## Application for a Non-Material Amendment Following a Grant of Planning Permission

Two storey side extension and single storey rear extension to dwelling

PF/22/2526

Increase width of window of first floor window to the office.

Dwg. Title
Planning Drawings - Scale as shown at A1

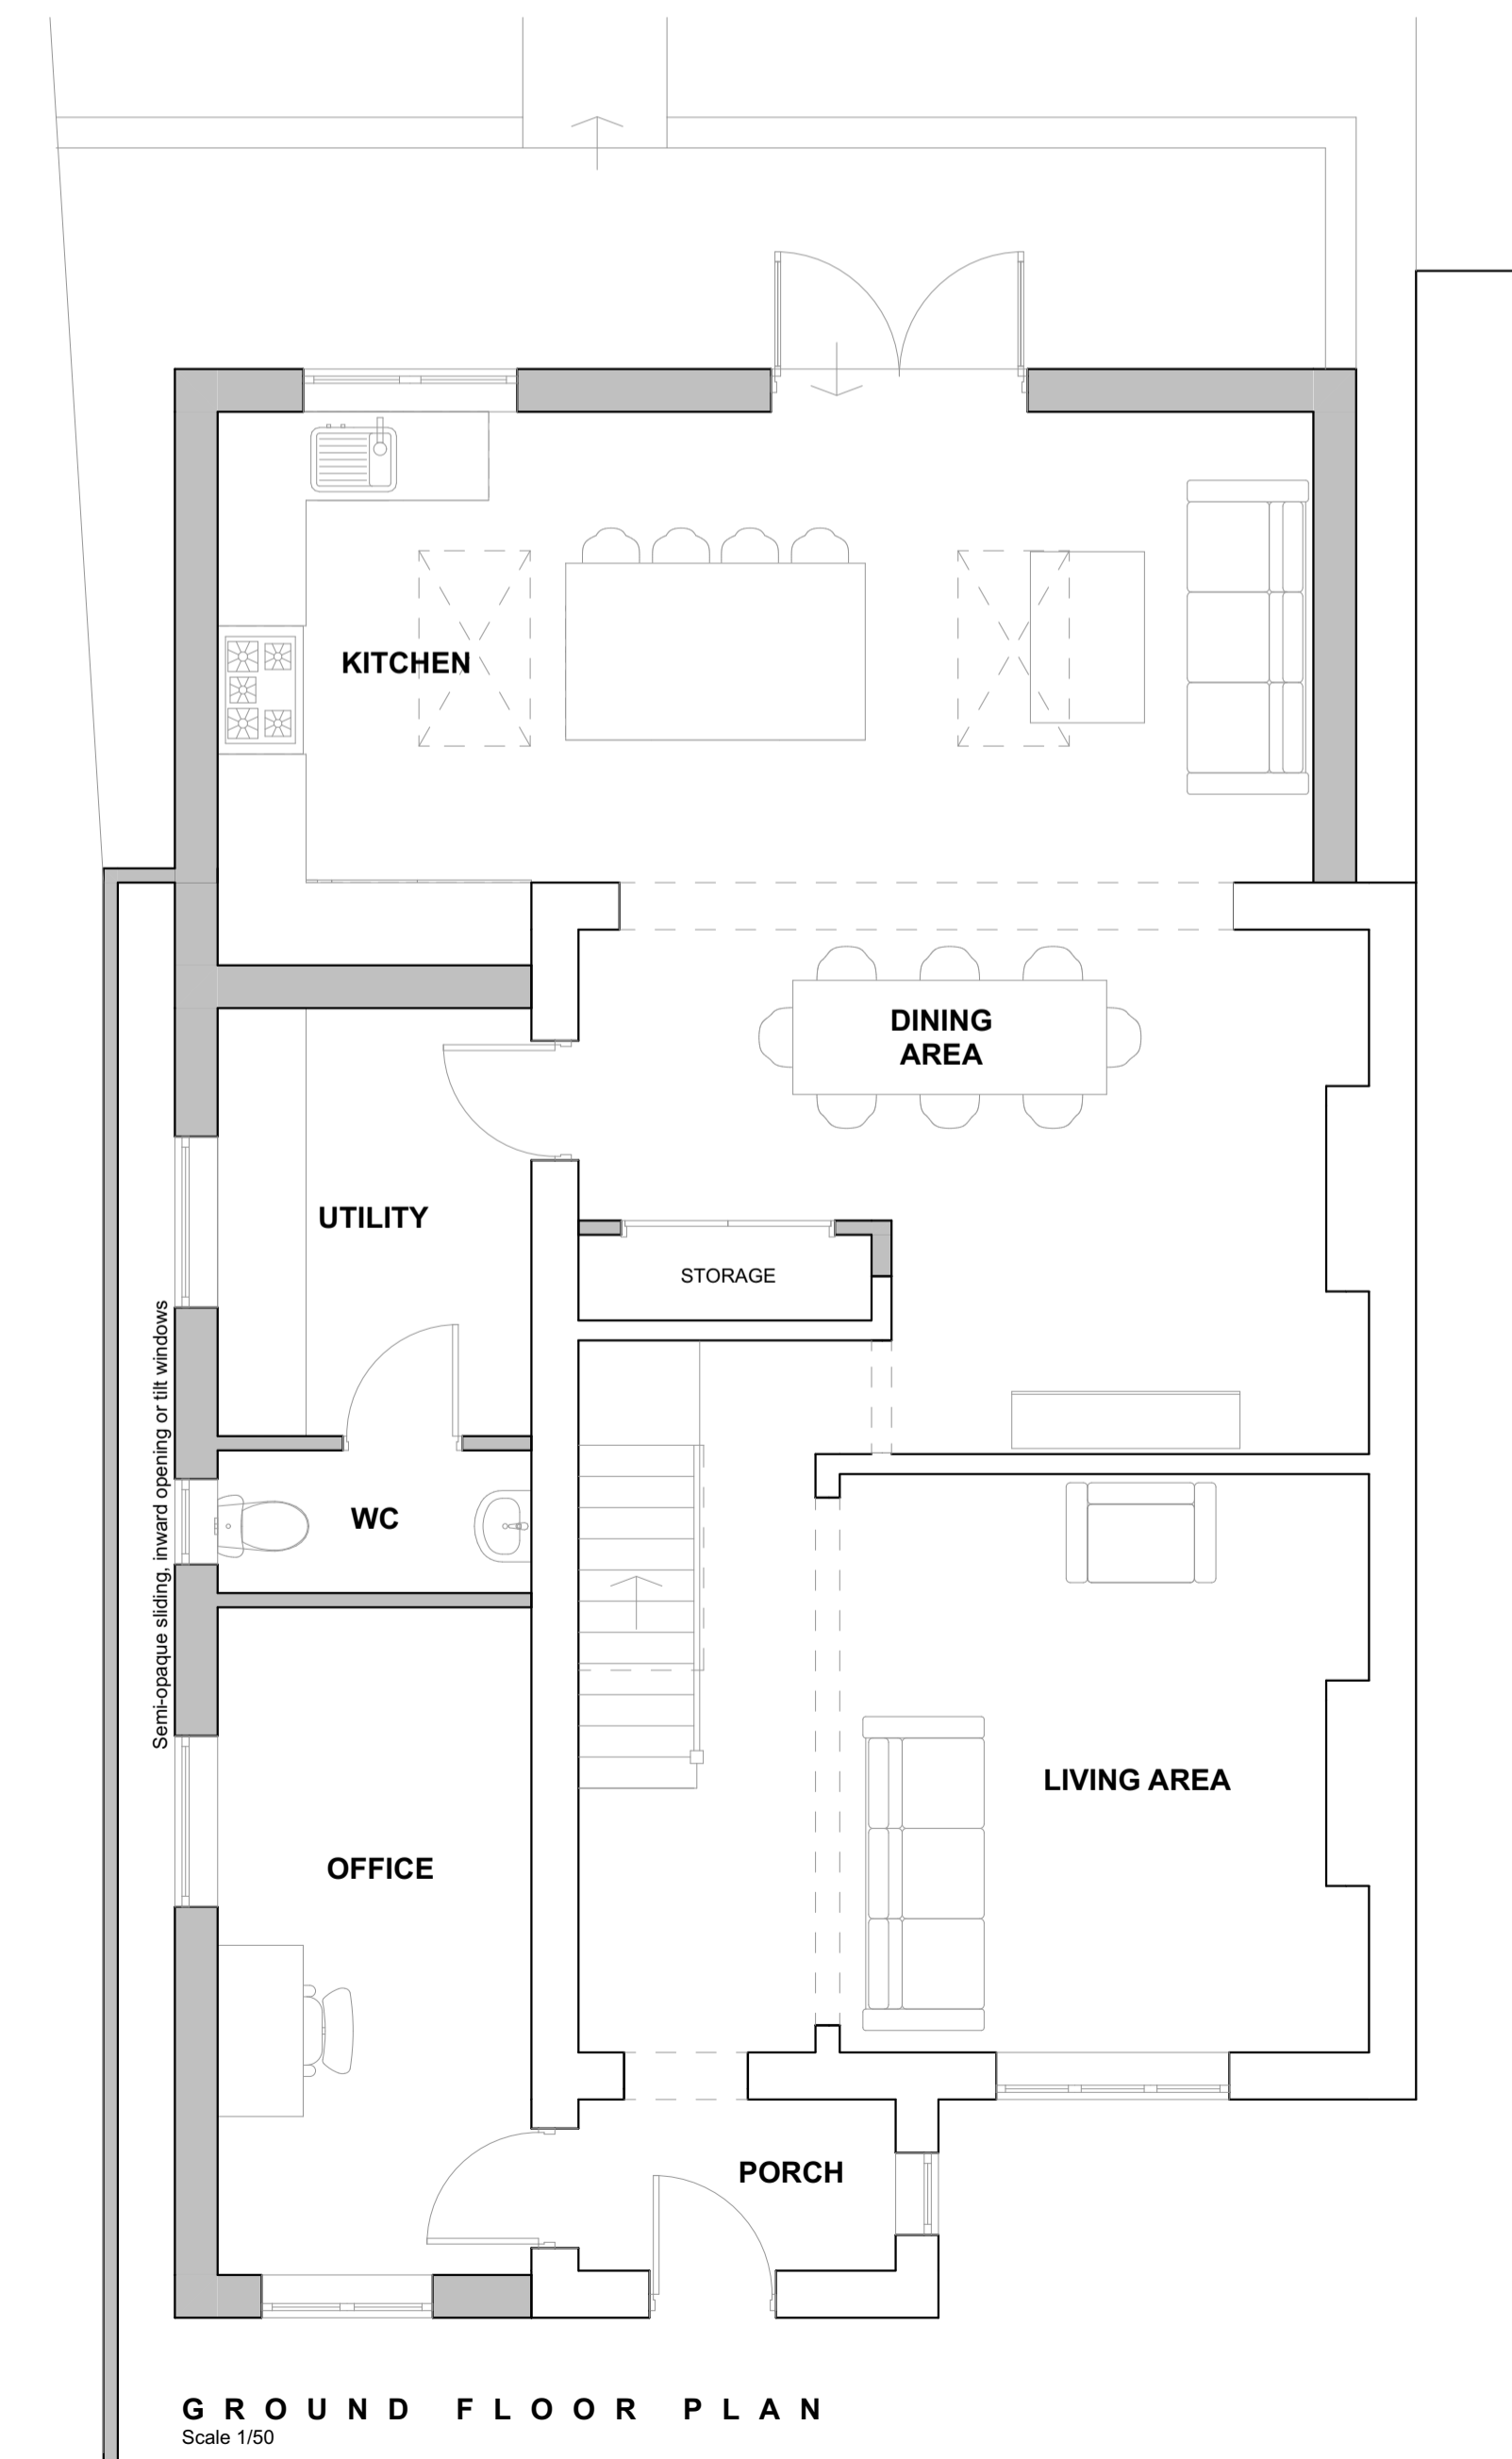
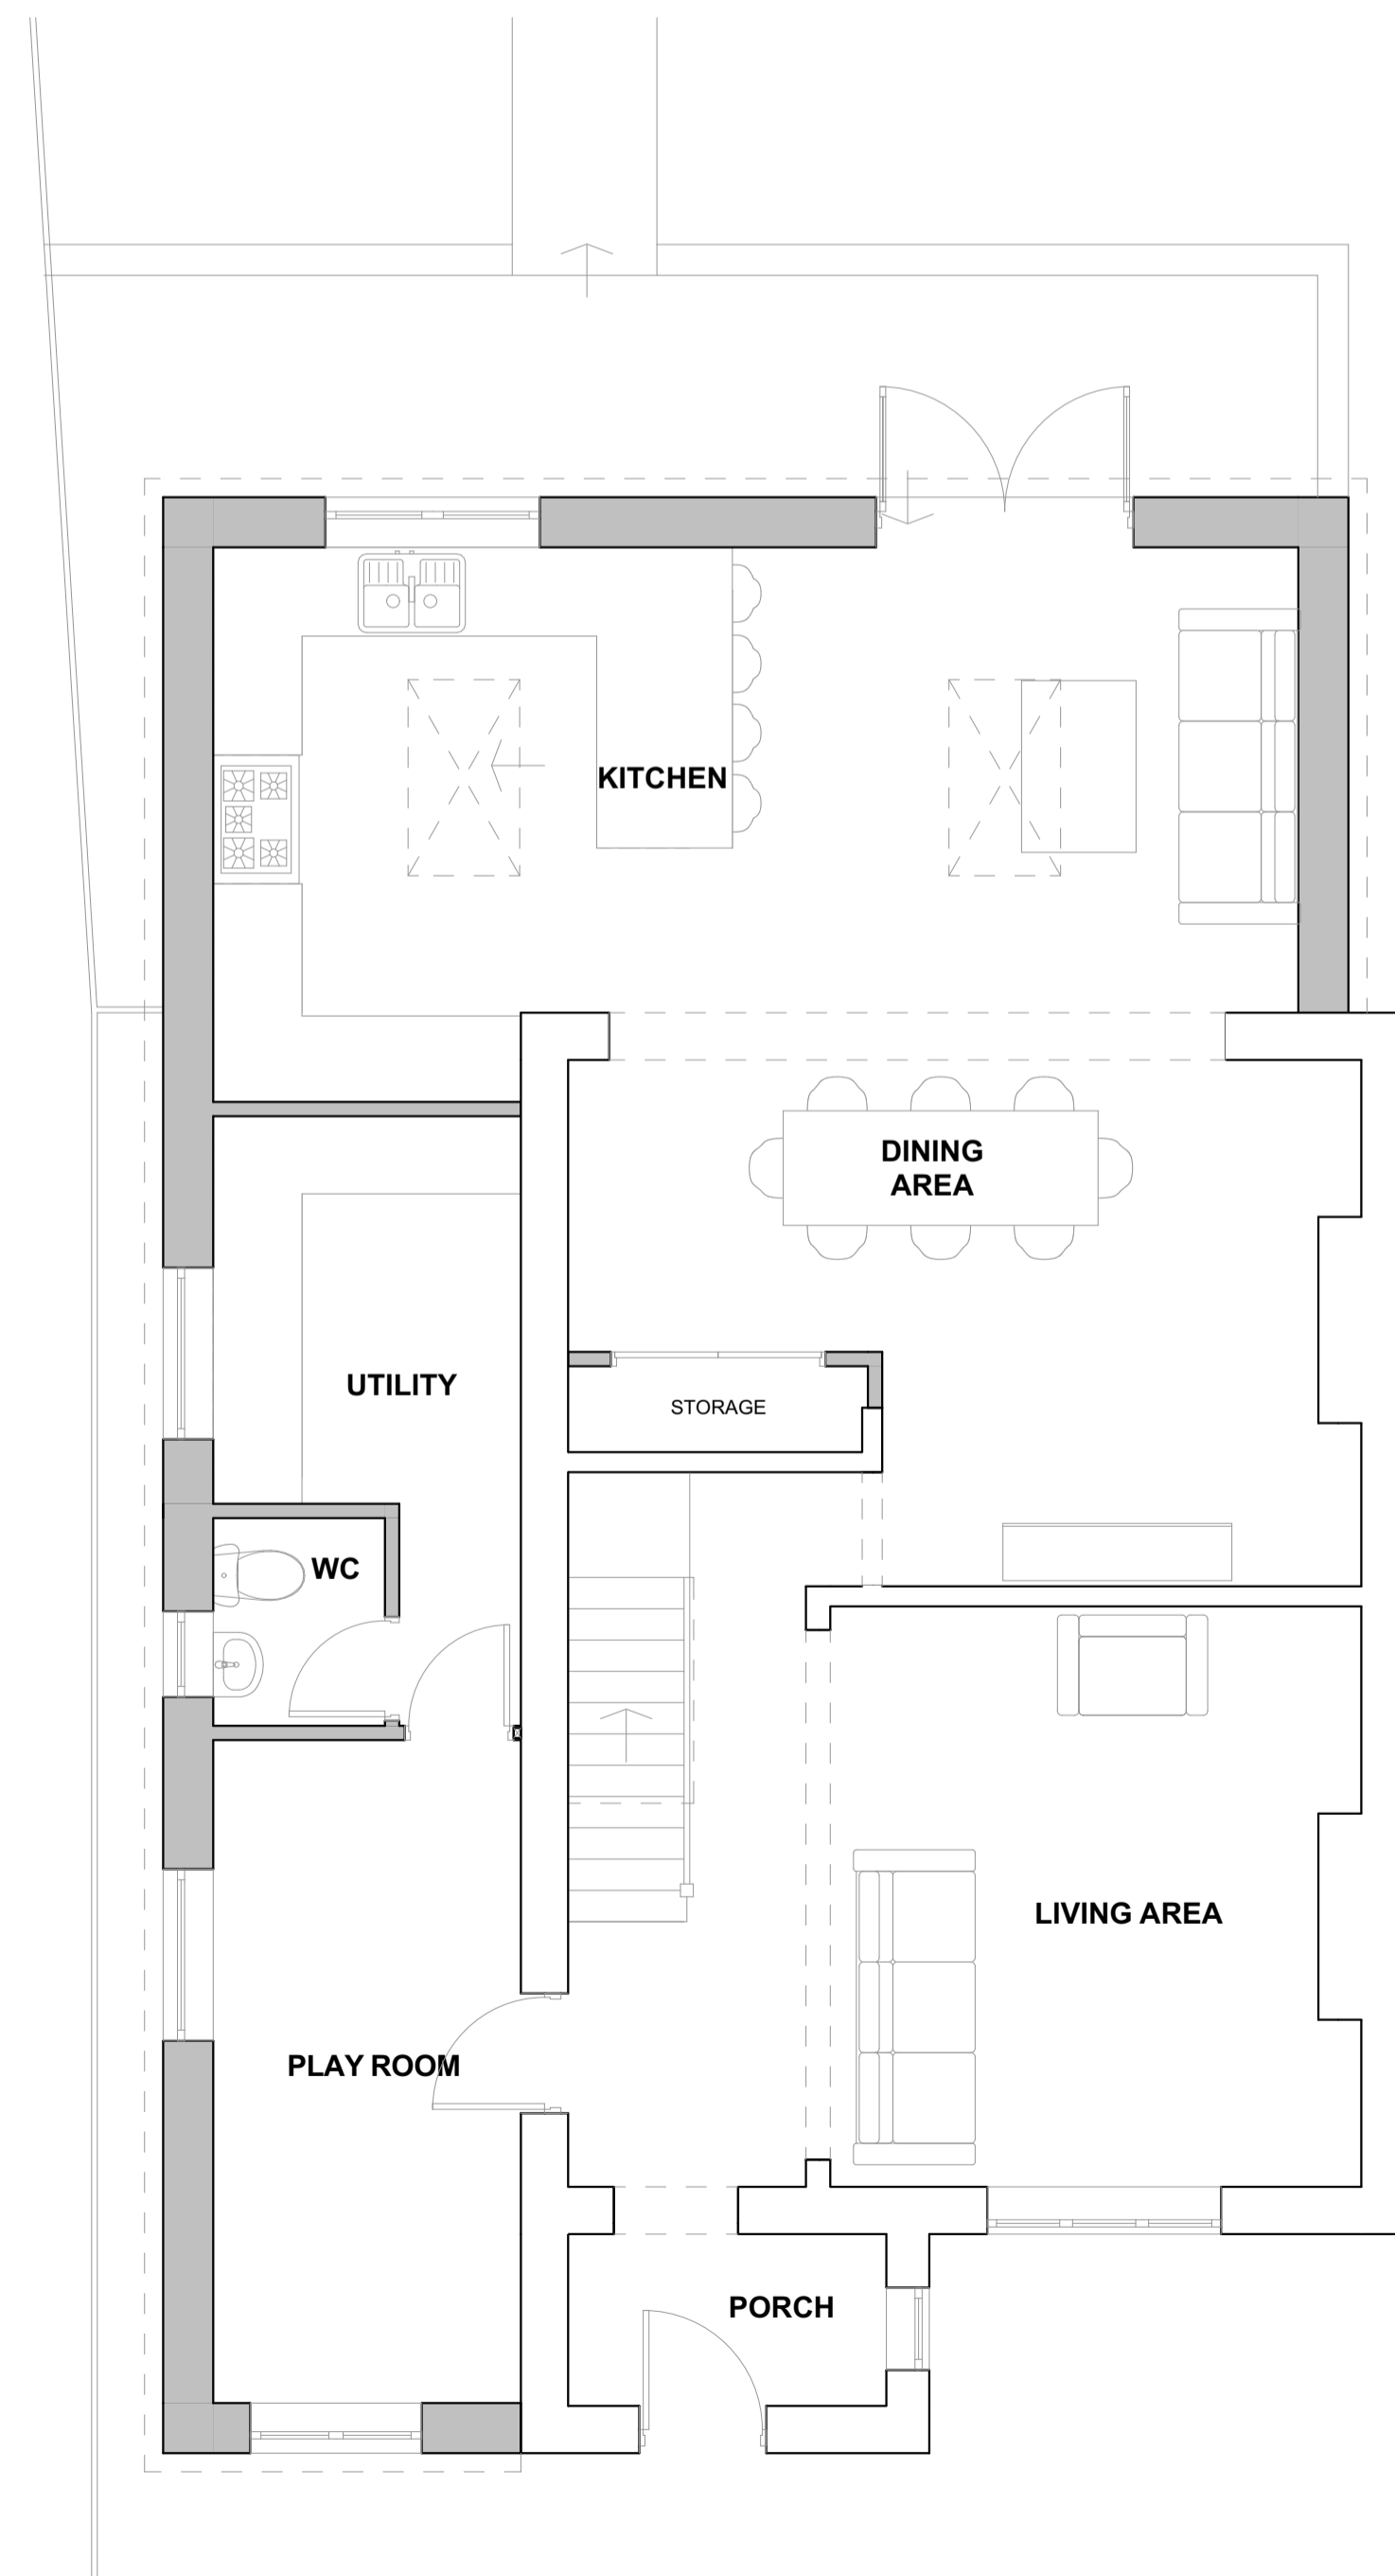
To provide more light and amenity

41 Pine Grove - Planning Drawings - Rev E
